Application No: EP/48/21/HH
Site Address: 2 Bay Tree Garden East Preston BN16 1JG
Description of works: Erection of single storey rear extension and rear dormer following the demolition of existing garage and workshop.

Thank you for your internet representation made on 5th June 2021 which has been recorded as an objection with the comments as follows:

First Floor Plan

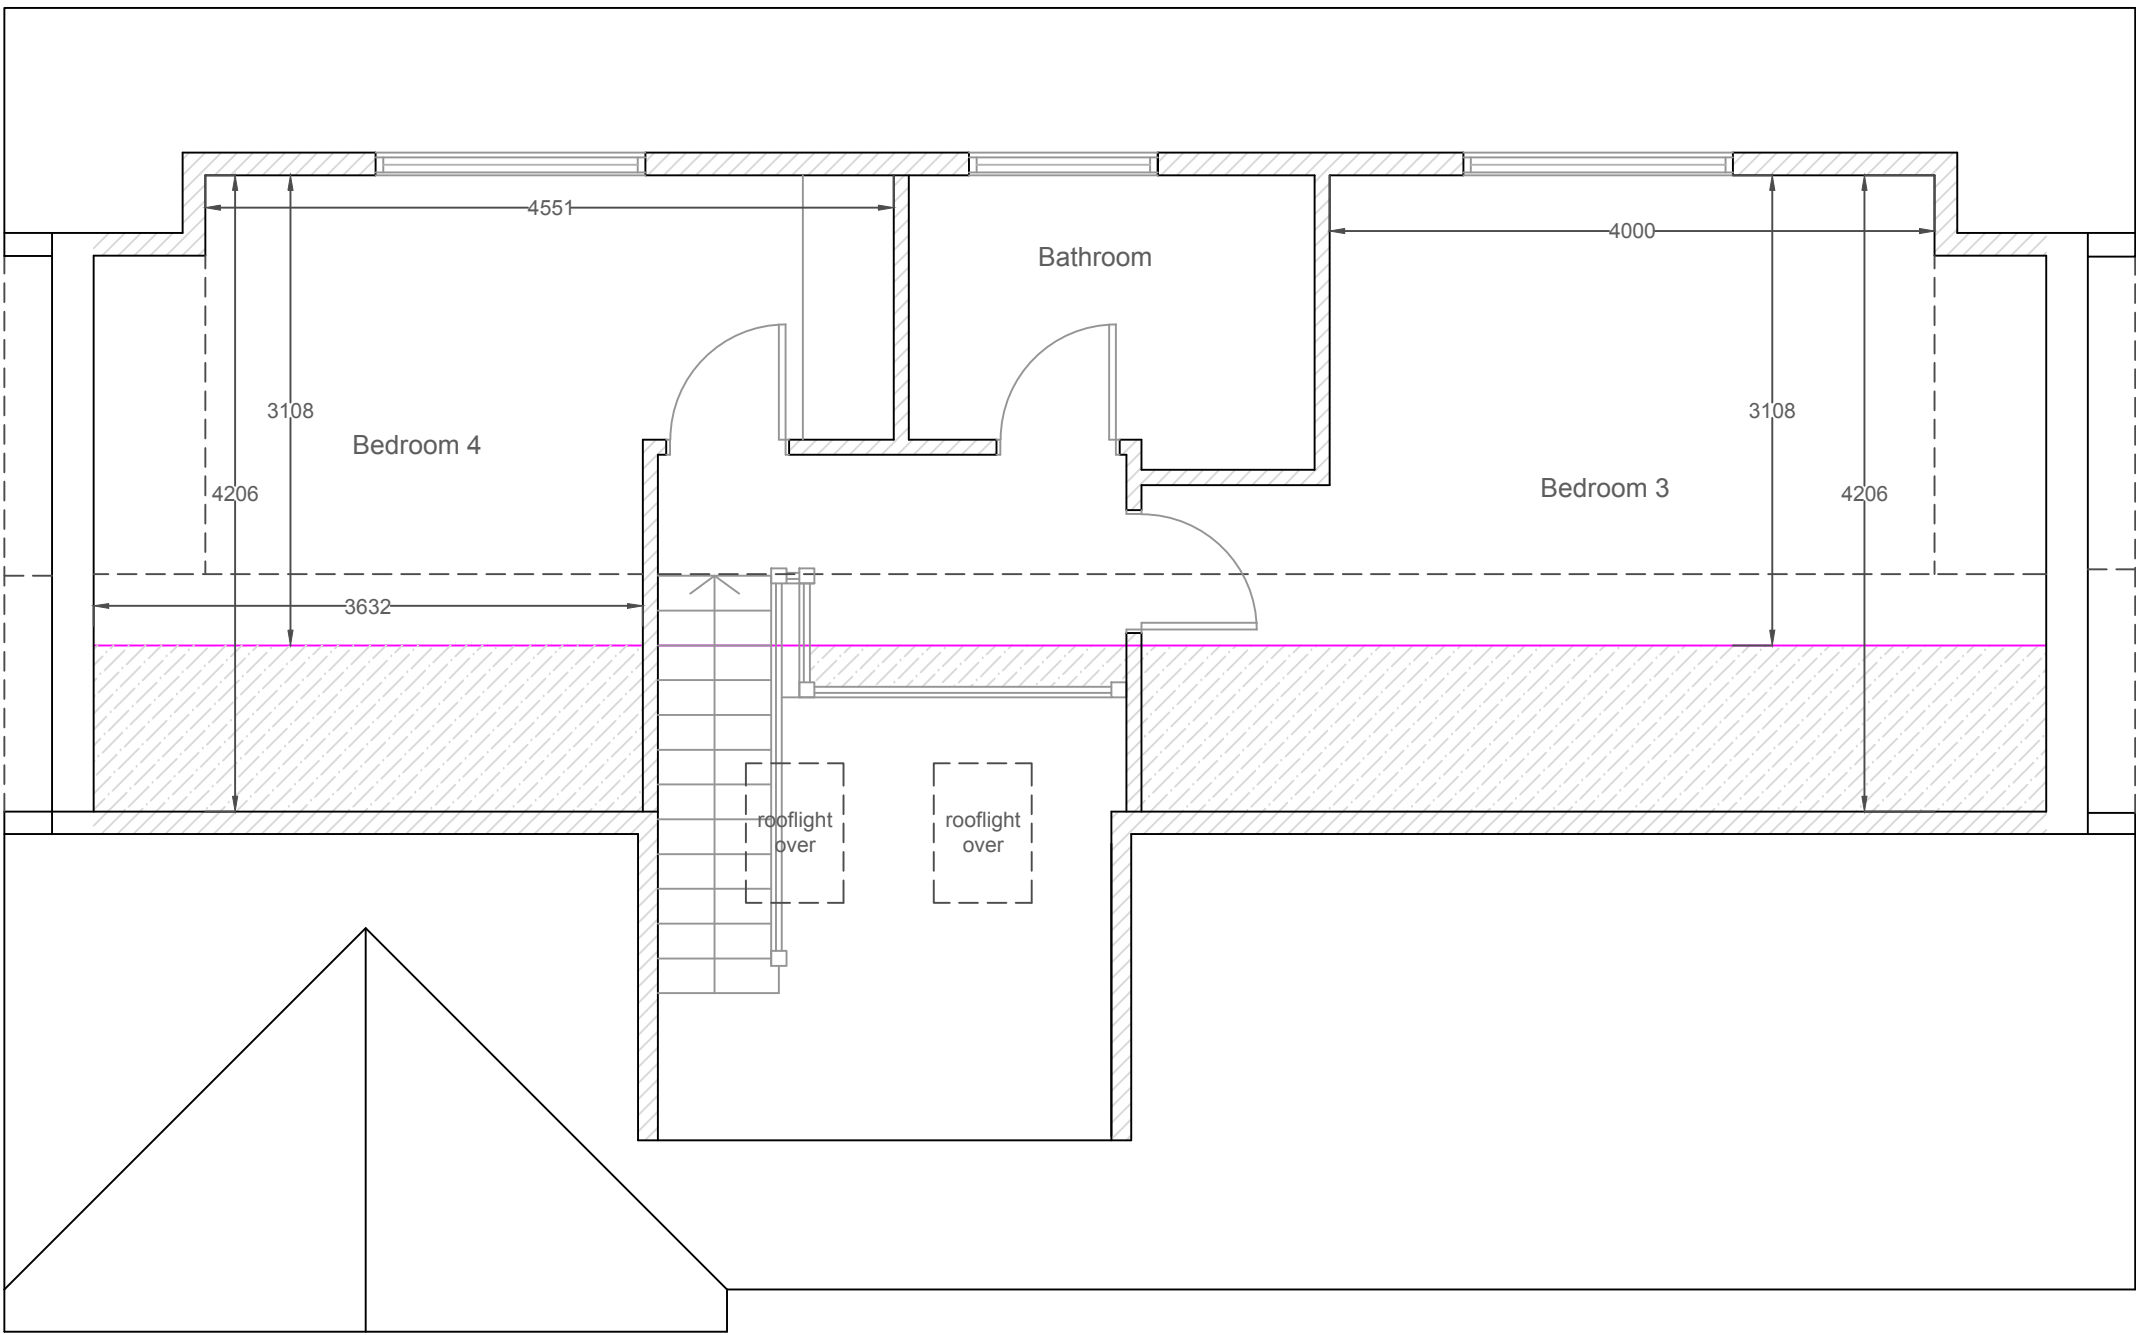
The proposed design of the dormer will overpower the look of the surrounding area due to its size and colour. The cladding of a black burnished wood and black roof tiles are not in keeping or sympathetic with the materials currently used on the external walls of the surrounding dwellings. Surrounding properties have traditional tiled roofs and tiled dormers, with red brick walls. Any deviation from this style, such as the proposed white rendering and black cladding would be in violation of Design Policy 4 of the East Preston Neighbourhood plan for Area 3, which states that:

The proposed dormer is oversized and includes unobscured windows that would look directly into our conservatory, dining room, kitchen, and master bedroom. In addition, it would overlook an established decking area at the bottom of our garden, which the borders on the boundary wall between ours and the applicant's properties (see attached photographs.)

The proposals to raise the roof would make the property stand out in the row of three bungalows and would not compliment the scale or massing of the surrounding buildings. Therefore, the proposed extension to 2 Bay Trees Gardens is in conflict with Policy D DM4 of the Arun Local Plan 2011-2031.
